## Appeal Decision

**Appeal Ref: APP/R5510/D/23/3323922**

**108 Fairway Avenue, West Drayton, Hillingdon, UB7 7AP**

- The appeal is made under section 78 of the Town and Country Planning Act 1990 against a refusal to grant planning permission.
- The appeal is made by Ms H Mangat against the decision of the London Borough of Hillingdon.
- The application Ref. 17799/APP/2023/475, dated 17 February 2023, was refused by notice dated 19 April 2023.
- The development proposed is construction of front porch.

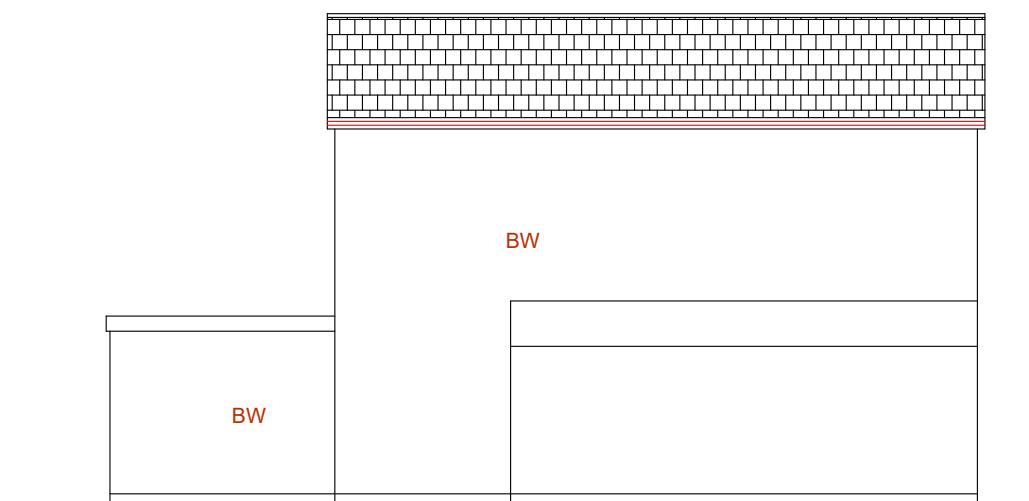
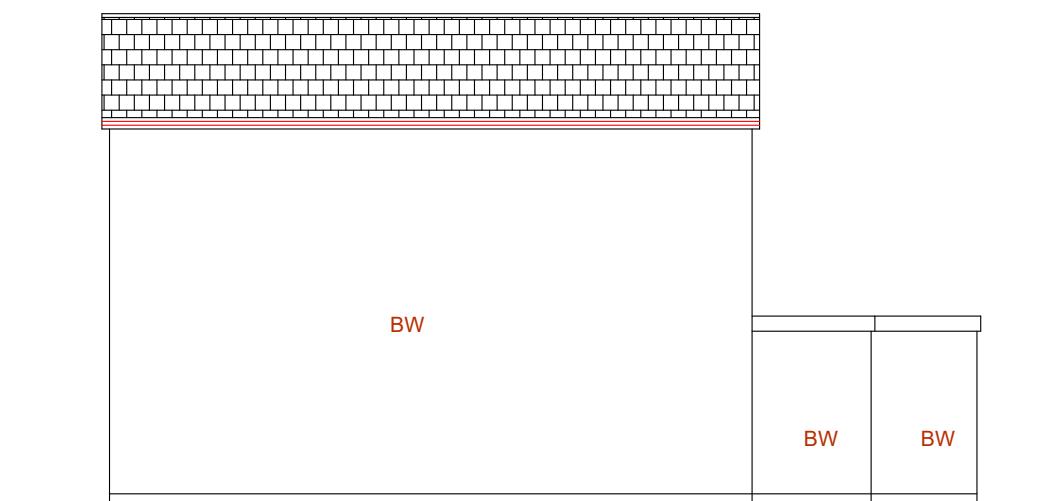
5. Within this context, the appeal proposal involves the construction of a porch on the front elevation to the host property. The proposed porch would have a width of some 3.1 metres and a depth of some 1.9 metres, and would be stepped back from the front wall to the existing single storey extension. The new porch would include a flat roof that would link to the flat roof on the extension. The pallet of materials would match existing and the new porch window would match that on the first floor to the main house.

8. Based on the above and the evidence before me, the proposed porch would involve the creation of a very small amount of additional floorspace which would not increase the number of rooms within the property but simply provide a weather tight area for the occupiers to use before they enter the main house. The proposal would involve a small scale extension that would be stepped back from the front wall to the existing ground floor extension. In view of this and its proposed design and window detailing, I am entirely satisfied that the proposal would be: subordinate to the host property: it would be in keeping with the design of the original house; and would retain and enhance the original features and detailing of the main house.

11. The Council have also referred to the policies in relation to front extensions, which require these to be minor and to not alter the overall appearance of the original house, and to not extend across the whole of the entire front elevation. However, the proposal before me is for a new porch and not a front extension. Even so, the scale of the new porch is modest, it is set back and extends to around half the width of the front elevation to the host.

1. The appeal is allowed and planning permission is granted for construction of front porch at 108 Fairway Avenue, West Drayton, Hillingdon, UB7 7AP, in accordance with the terms of the application, Ref. 17799/APP/2023/475, dated 17 February 2023, and the plans submitted with it and subject to the conditions listed below.
  - 1) The development hereby permitted shall begin before the expiration of three years from the date of this permission.
  - 2) The materials to be used in the construction of the external surfaces of the development hereby permitted shall match those used in the existing building.
  - 3) The development hereby permitted shall be carried out in accordance with the following approved plans: ART/2023/FP108FW/SPLP Rev.B; ART/2023/FP108FW/ELPL; ART/2023/FP108FW/PE.
